Re Land at Summer Lane - P/58/15/OUT

As outlined below I strongly oppose the Planning Application P/58/15/OUT off Summer Lane.

SUMMER LANE - TOPOGRAPHICAL SURVEY

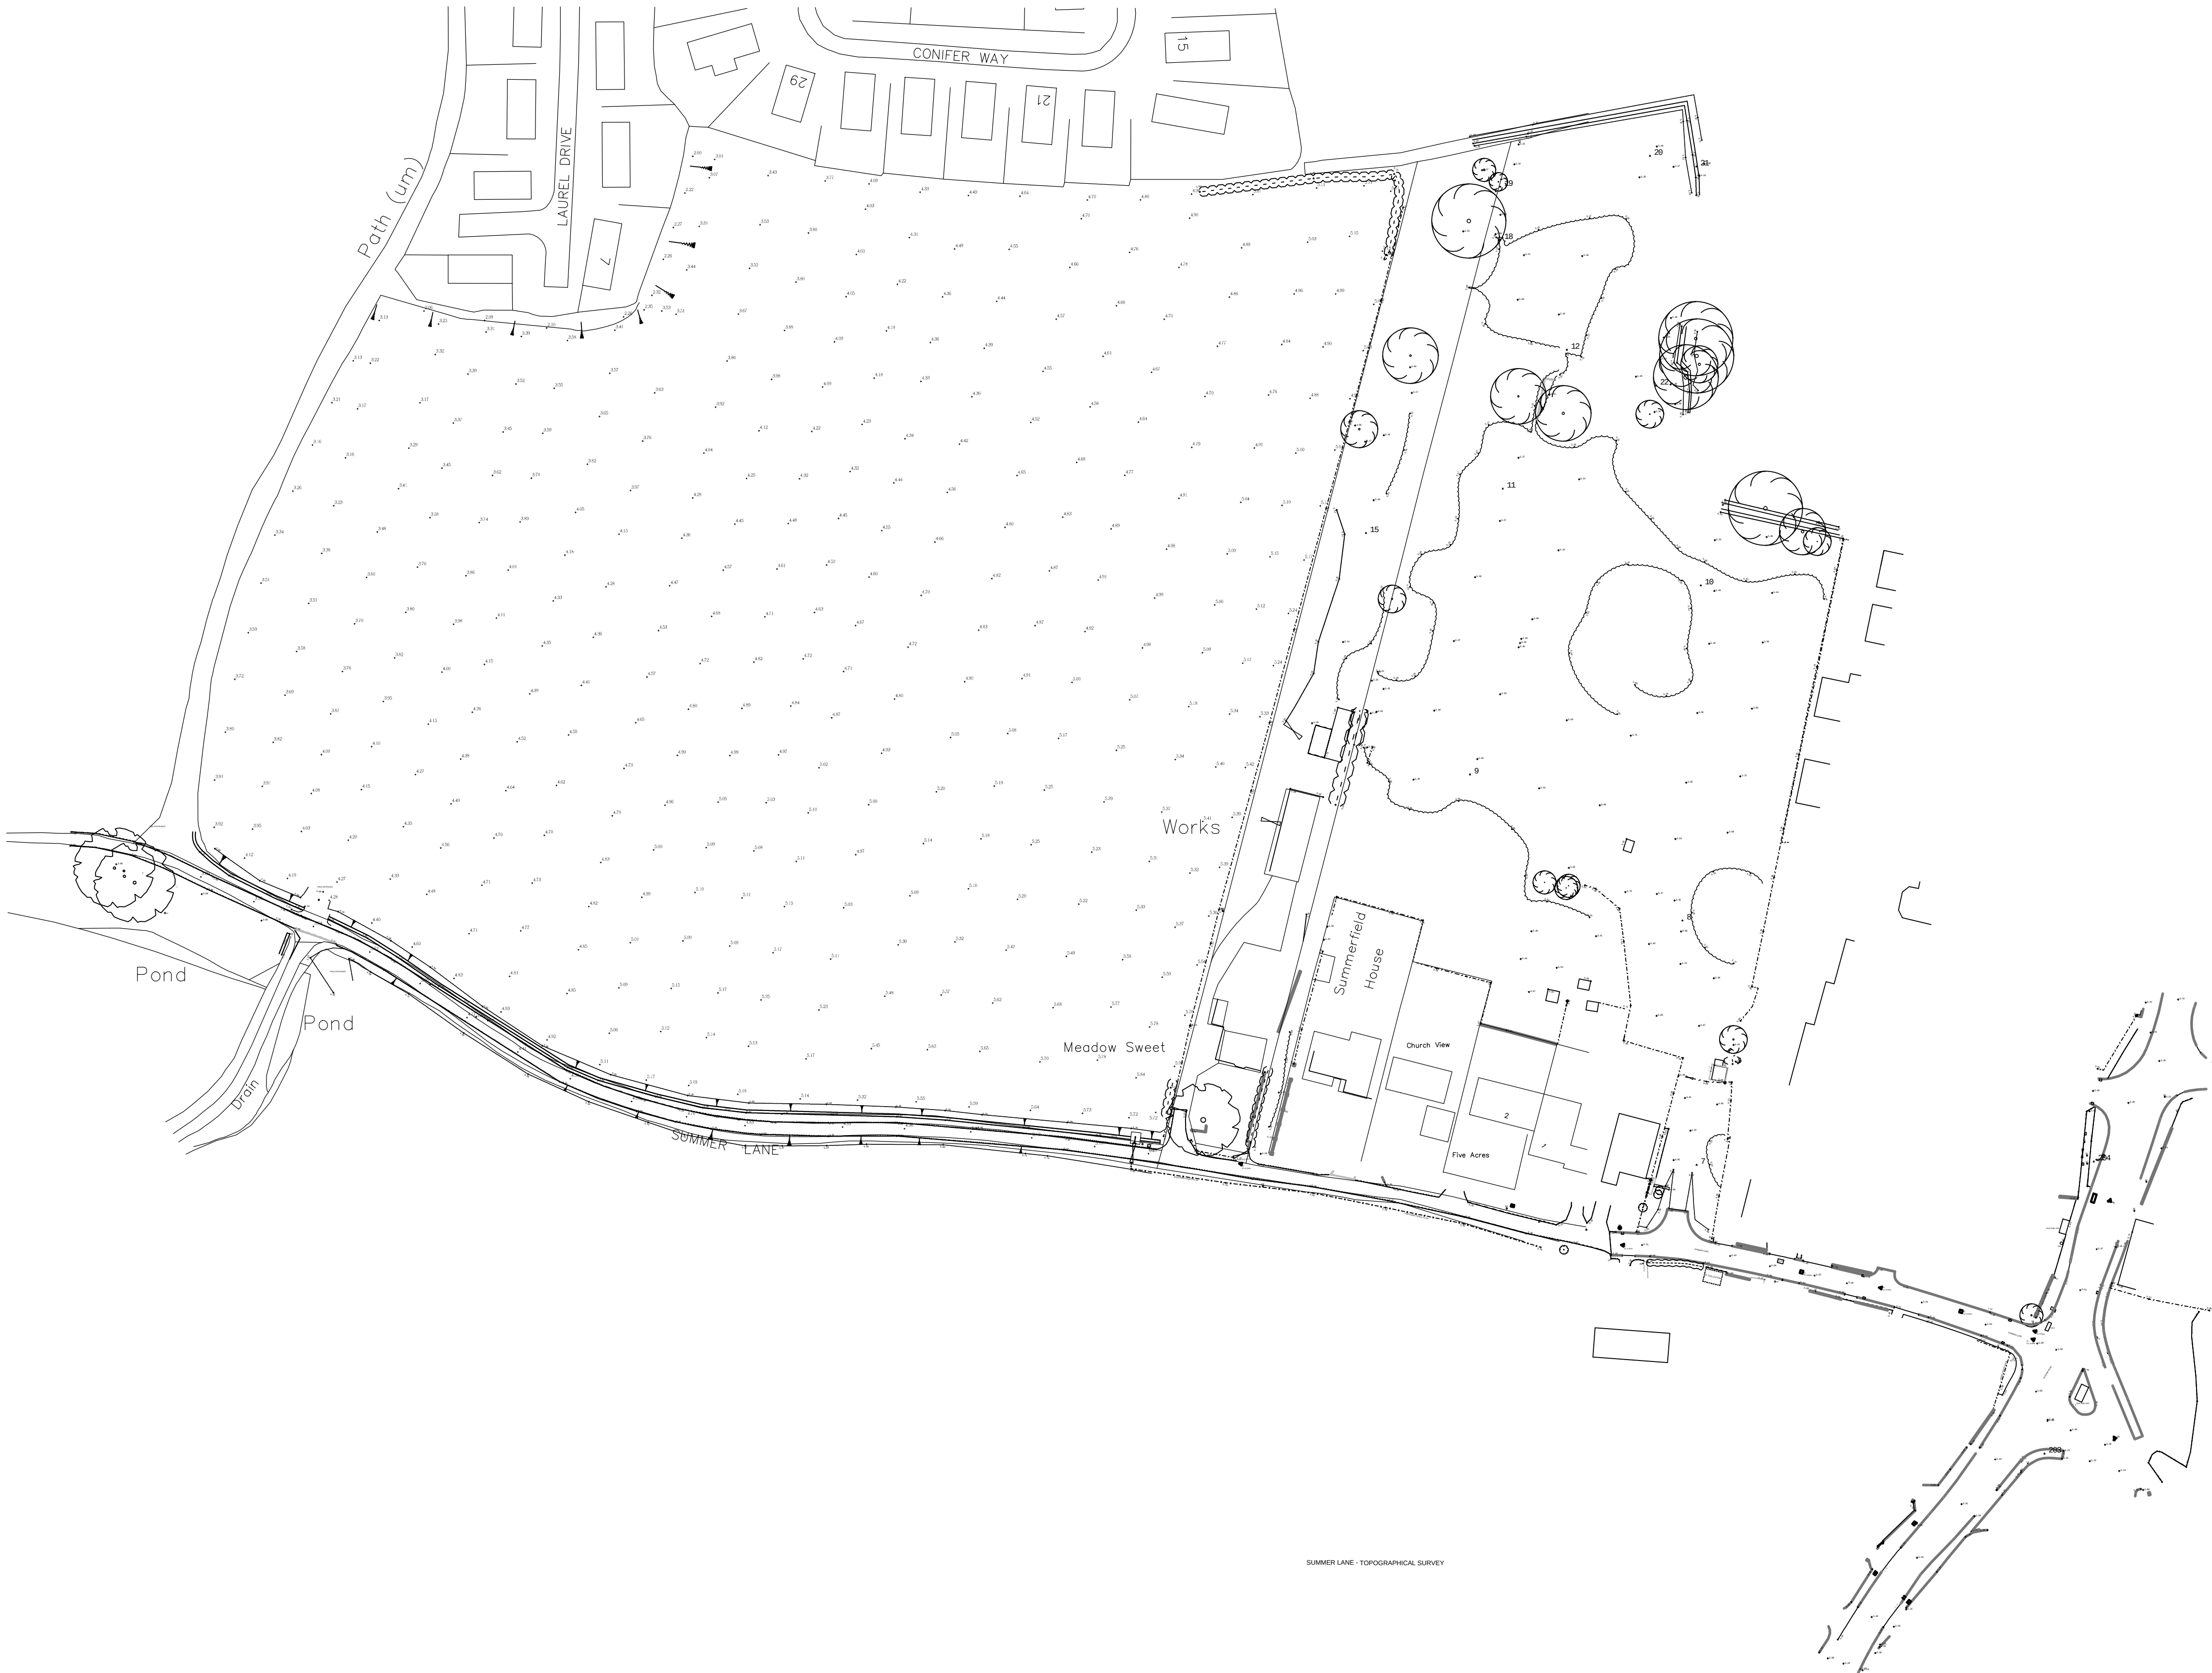
2 The plan also provides for the relocation of the footpath to the north side, this plan does not then provide suitable safe width for the properties at the entrance to Summer Lane on the south side of the redesigned Road. There will also be visibility issues from the accesses for the south side existing dwellings. (See Appendix B)

“The arrangement shown would also involve relocating the existing narrow footway from the southern side of Summer Lane to the north. In principle, there would be benefit to this given the widening of the footway that would result. Removing the footway from the southern side of the carriageway may have consequences for visibility from the accesses for those existing dwellings. It would appear that visibility may be substandard based on the existing arrangements, the proposed works would potentially worsen matters. Again, this matter should be appropriately considered with it determined how much of an impact would result from relocating the footway”.
